Our Ref: R/2024/4
File No: 2024/308631
Your Ref: SSD-67588459

SSD-67588459 – Environmental Impact Statement – Powerhouse Ultimo Revitalisation

The development involves a revised proposal for the Powerhouse Ultimo site at 494-500 Harris Street, Ultimo. The City previously provided extensive advice for the previous application. It is understood that this earlier consent has now been surrendered.

SHORT SECTION 1
SCALE: 1:200

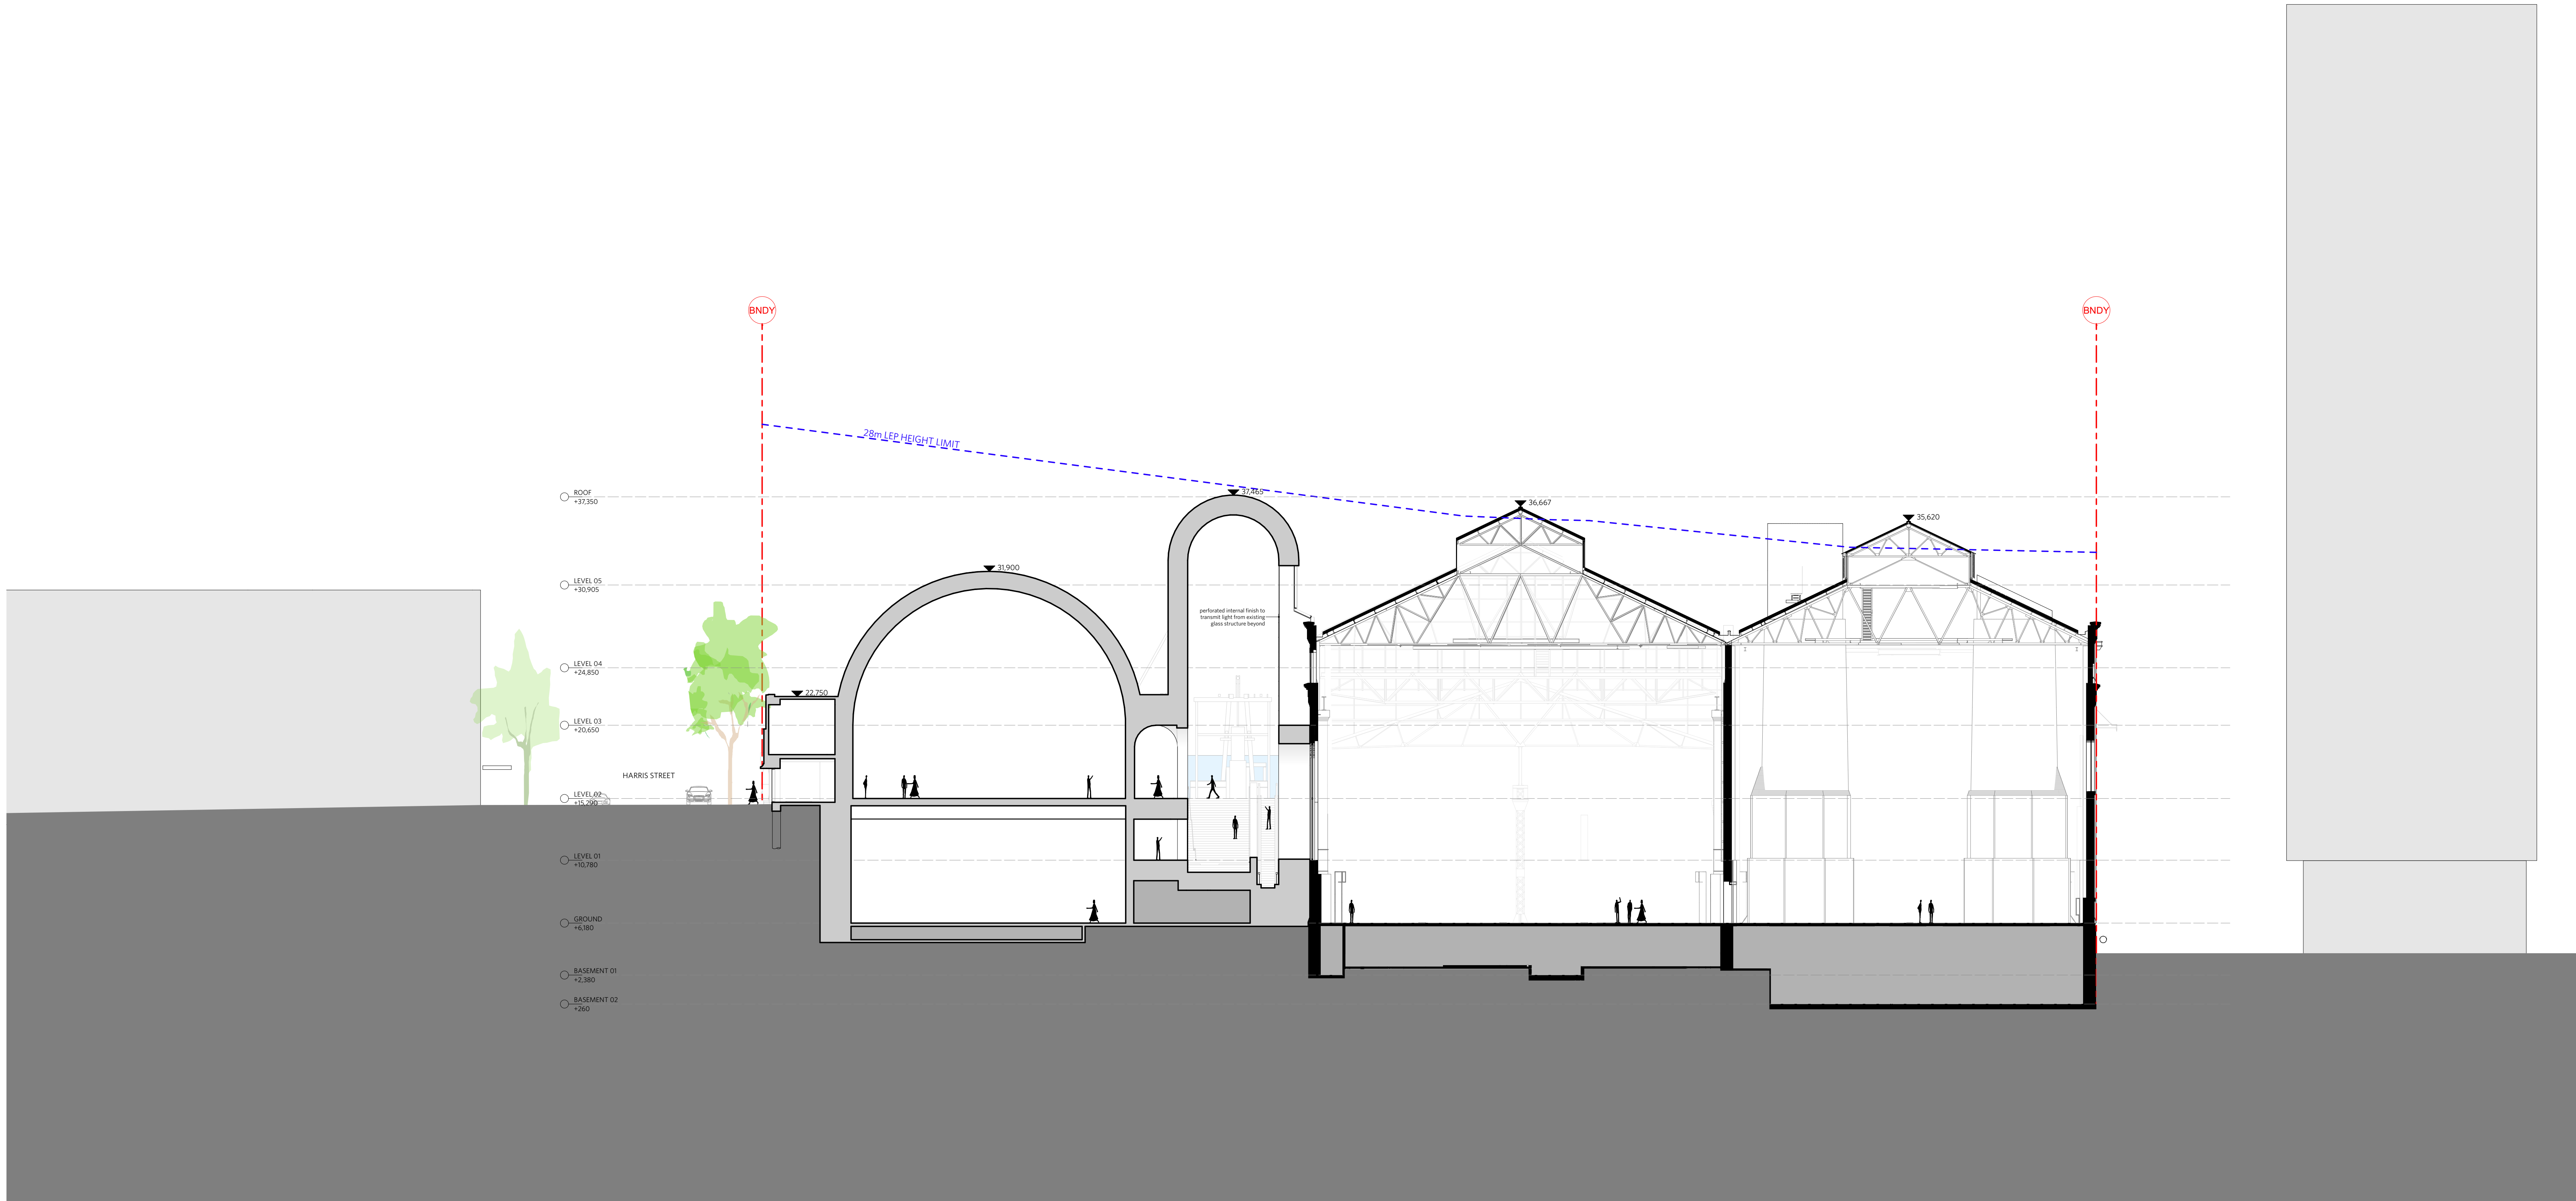
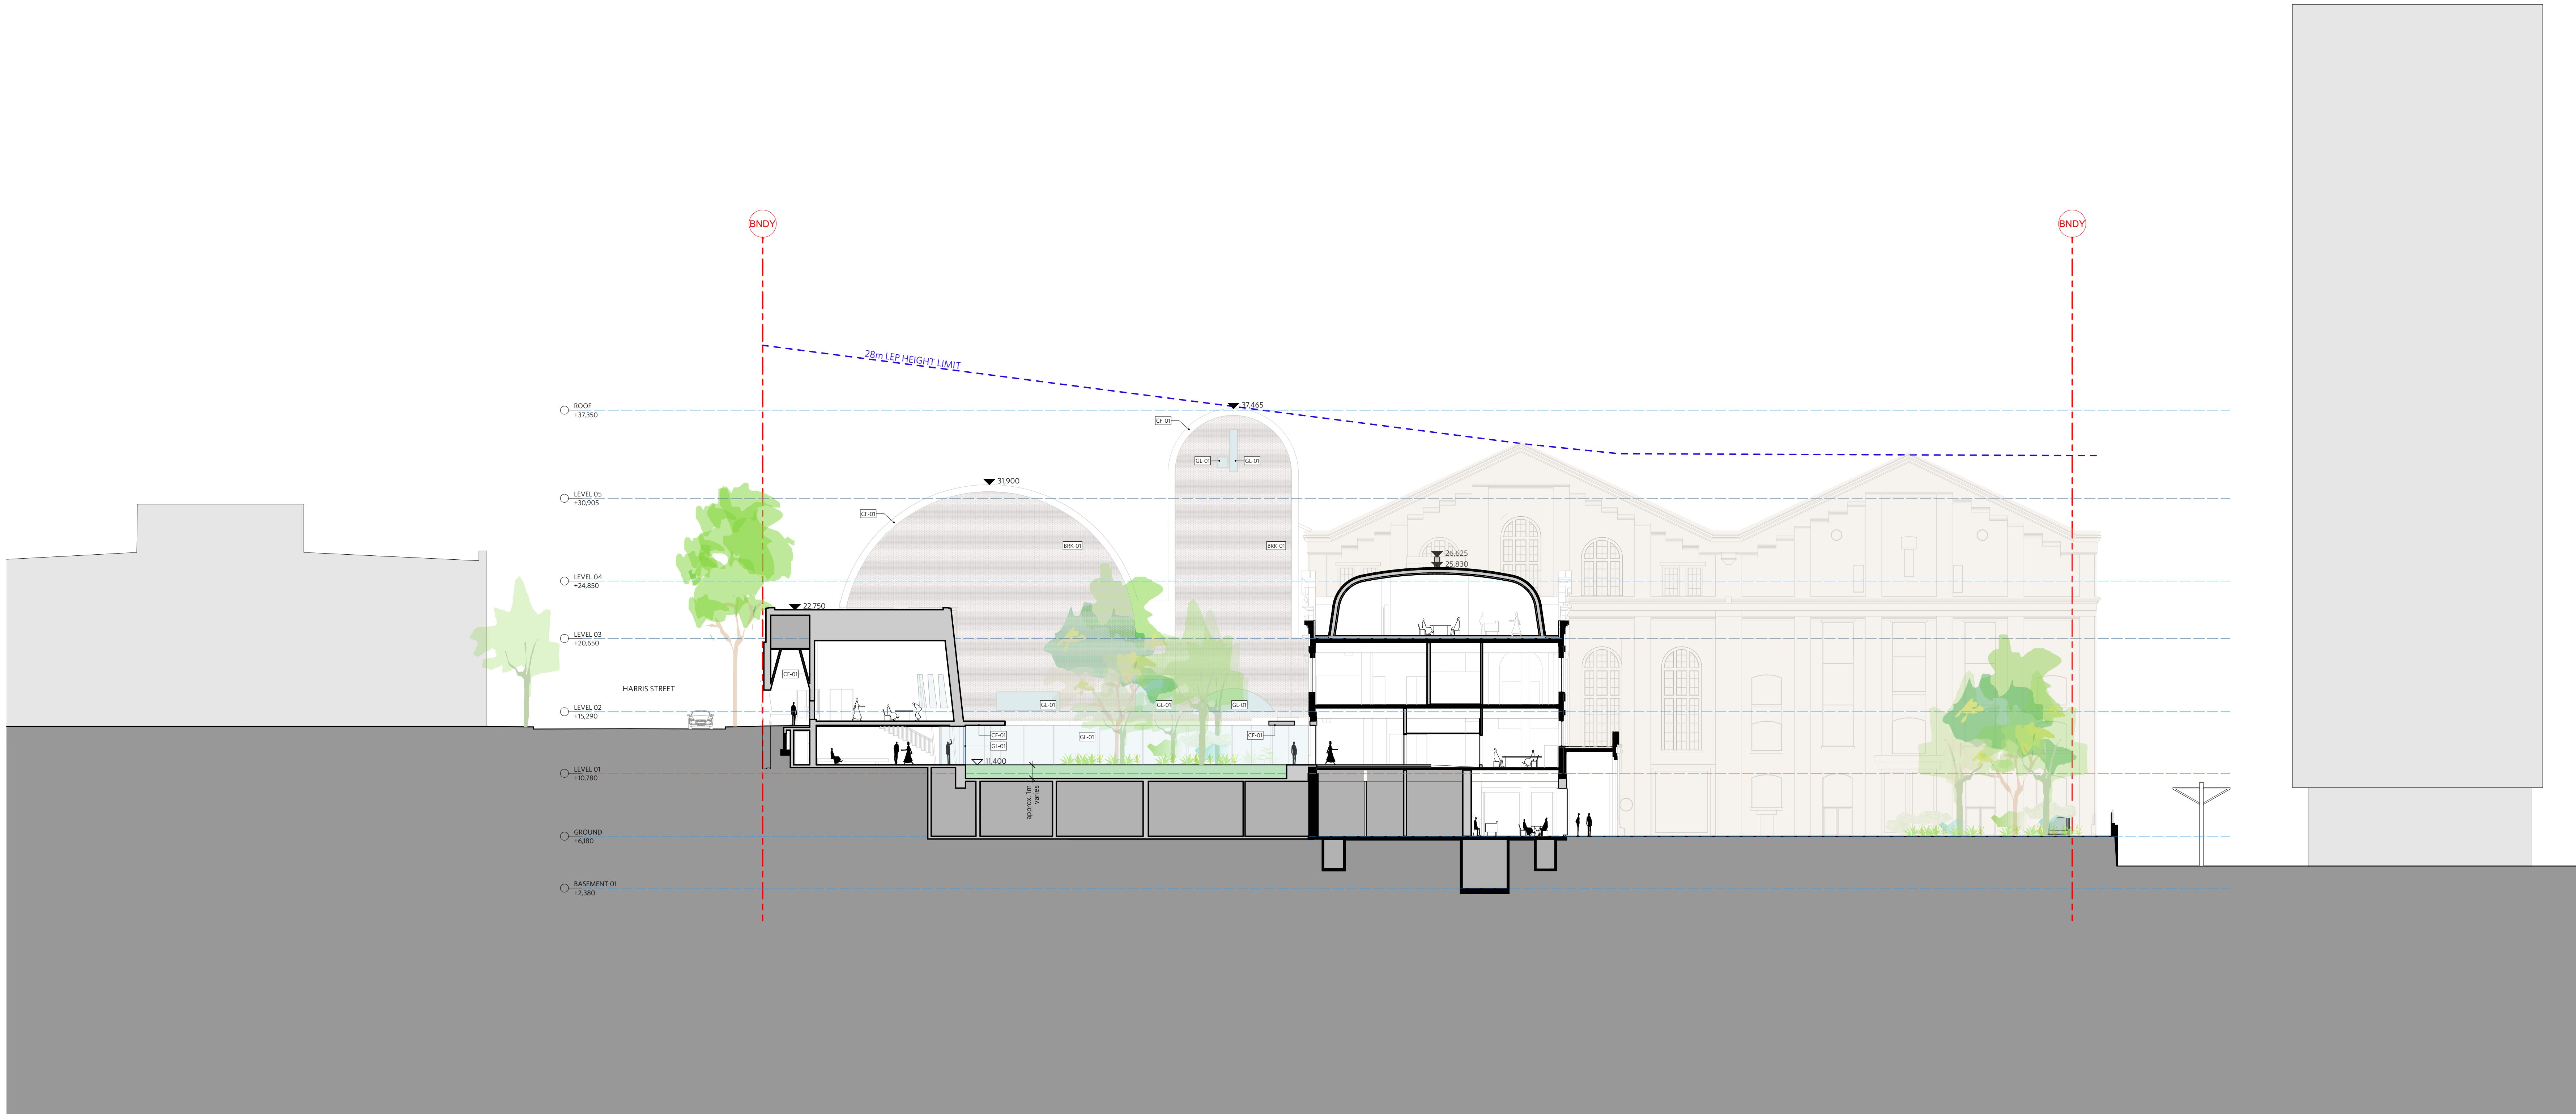
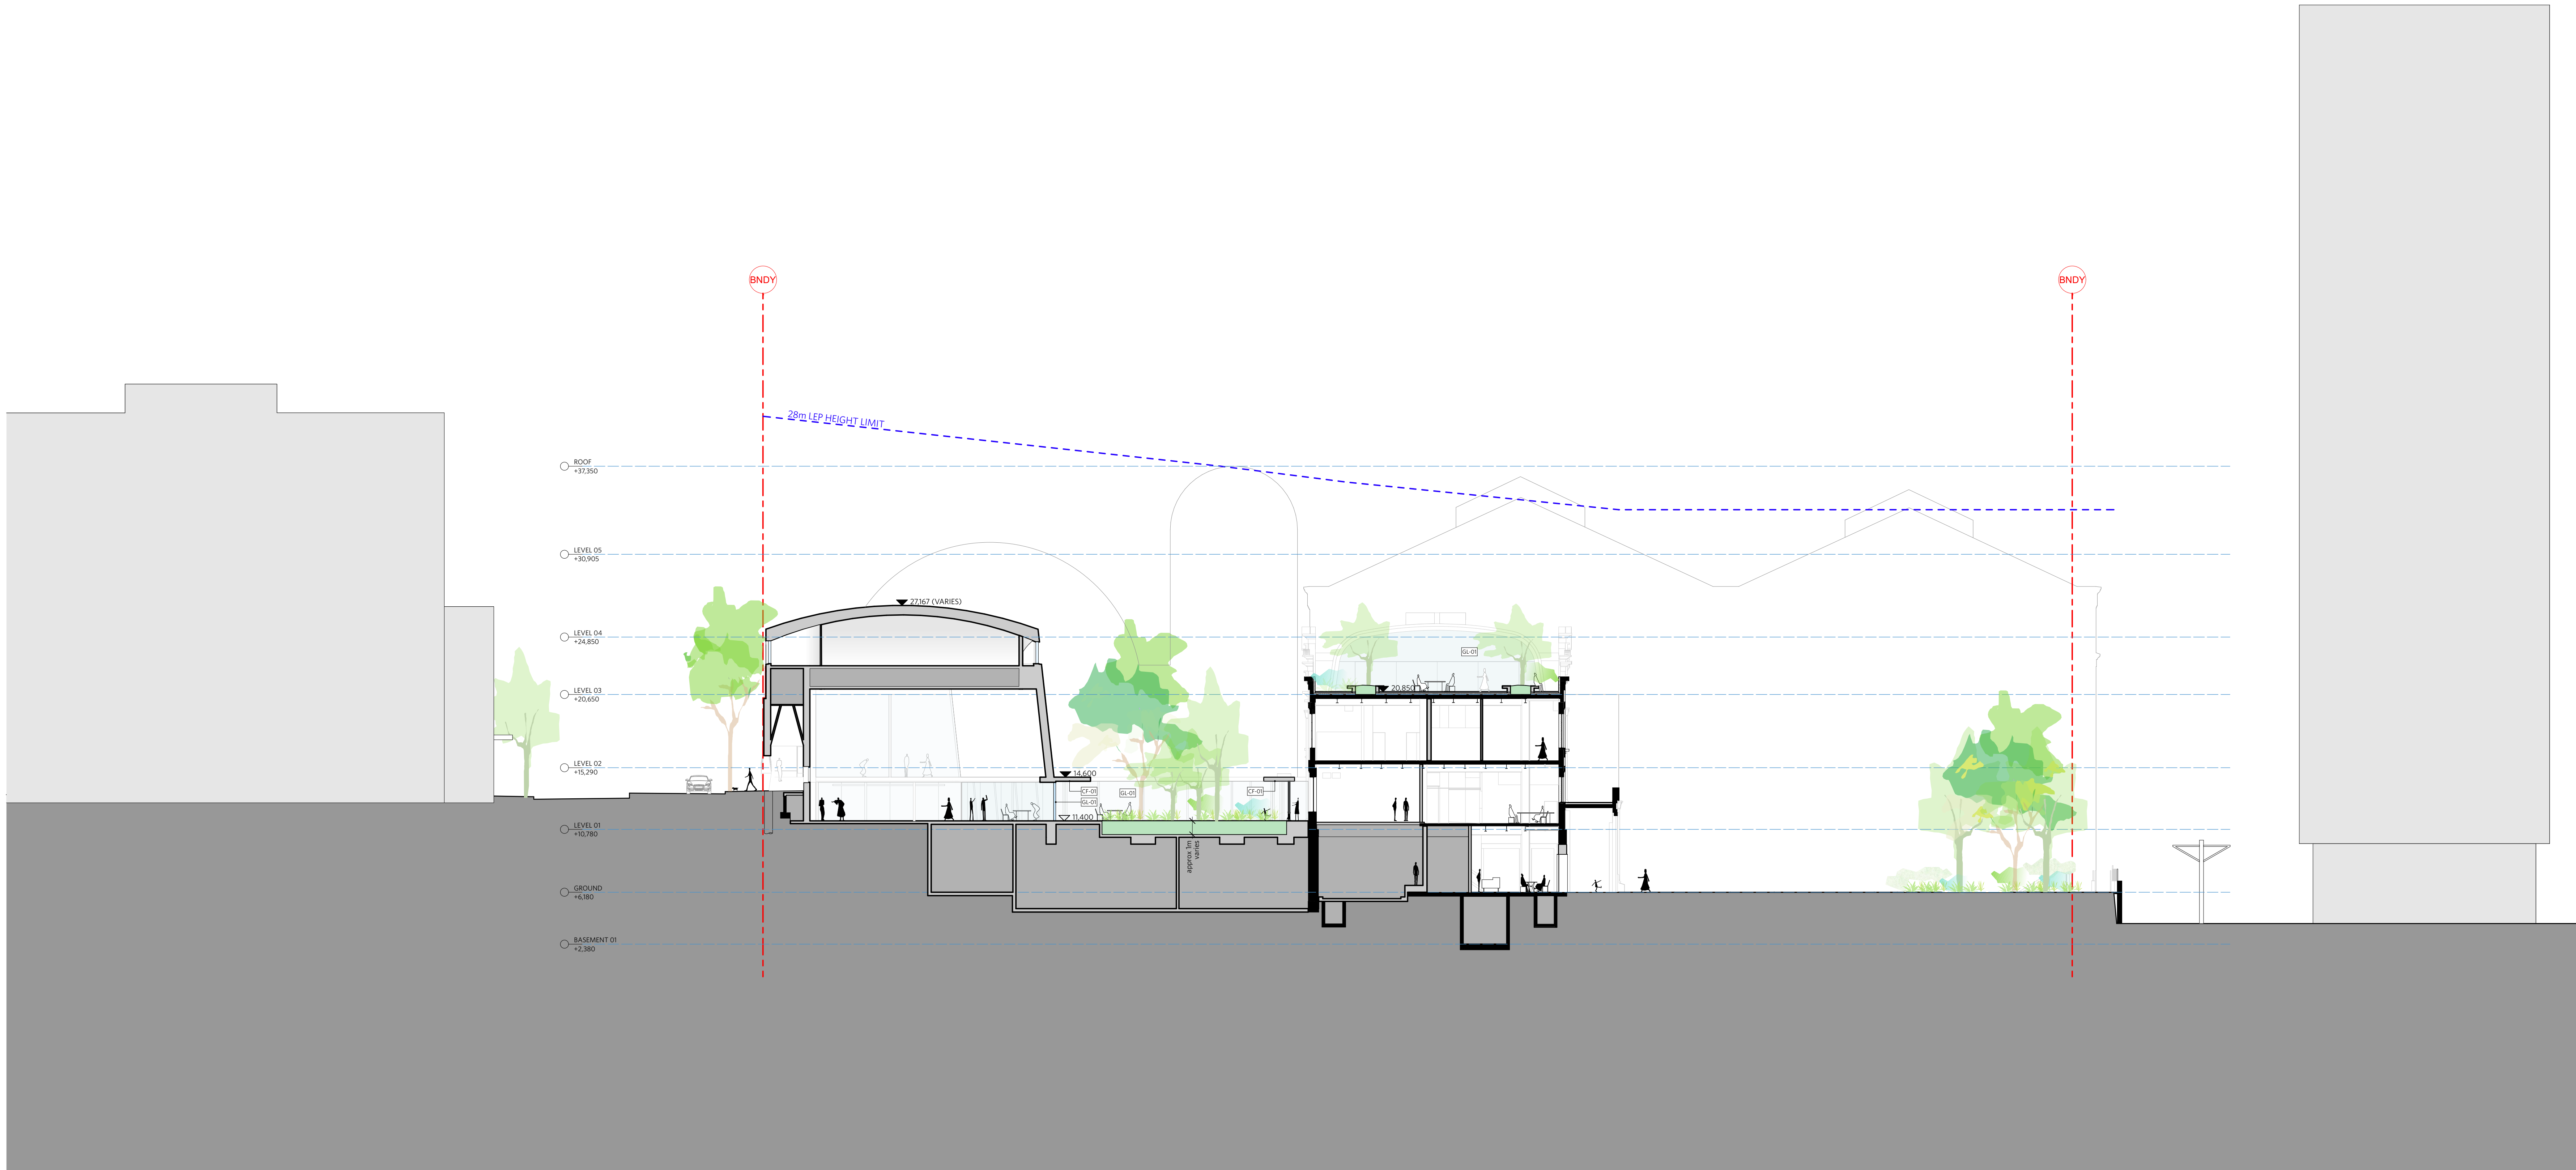
The adaptive reuse of the Wran Hall is unclear at this stage. The demolition plans show some internal structural columns being removed. L24 demolition plan shows the external wall to Harris Street being retained and the roof appears to be retained on the L5

demolition plan. There are no demolition plans shown in sections to understand if the structural steel frame that forms the barrel vault is retained in part or full. More detailed demolitions plans should be provided in plan, elevation, and section.

BRK-01: RECYCLED AND RECONSTITUTED BRICK, STONE AND CONCRETE

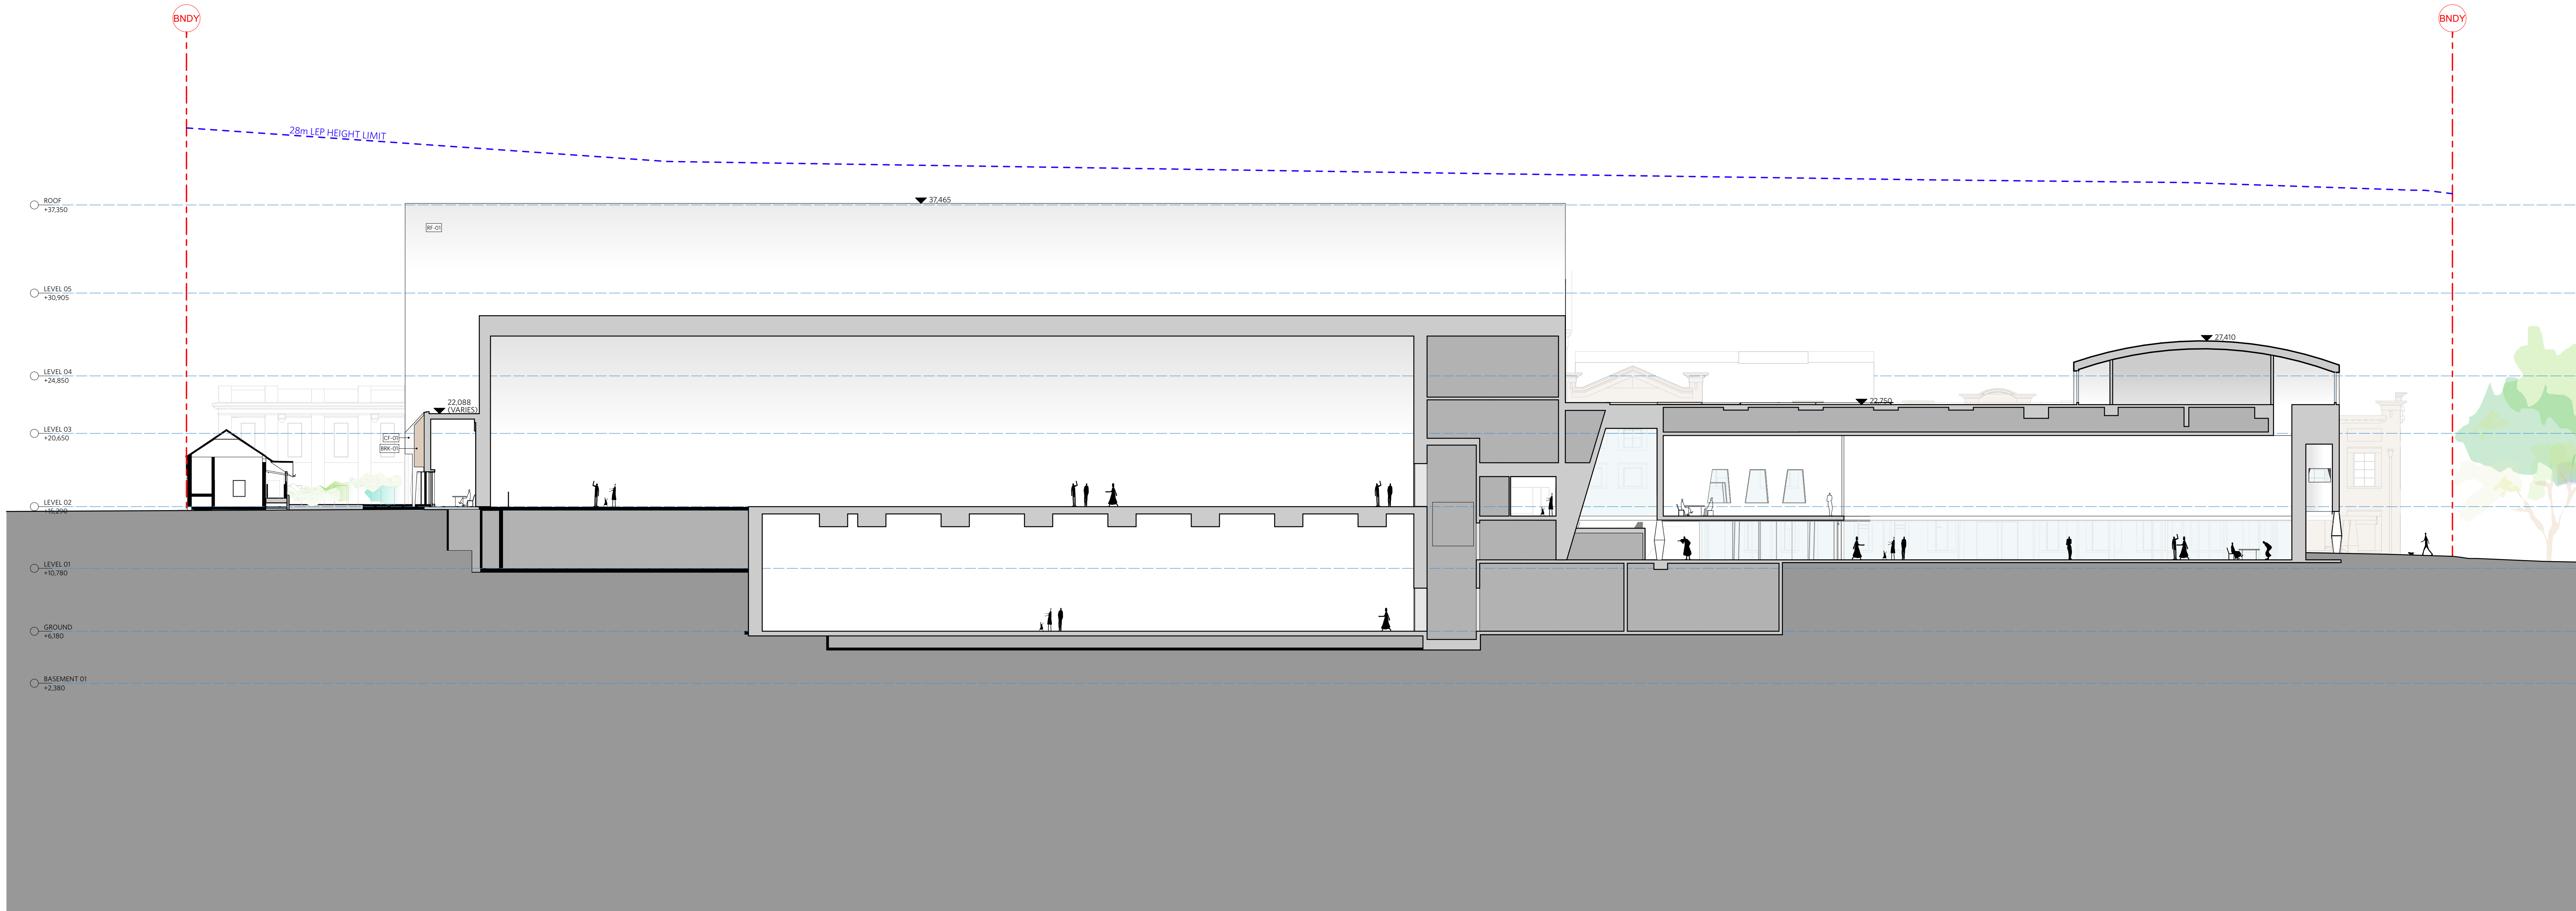
There is only a very limited palette of materials shown on the architectural drawing set:

The proposed materials and finishes need to be further clarified and the drawings should be amended to clarify materials and key these to the elevations and sections. This is also requested to assist in assessing the potential heritage impacts of the additions.
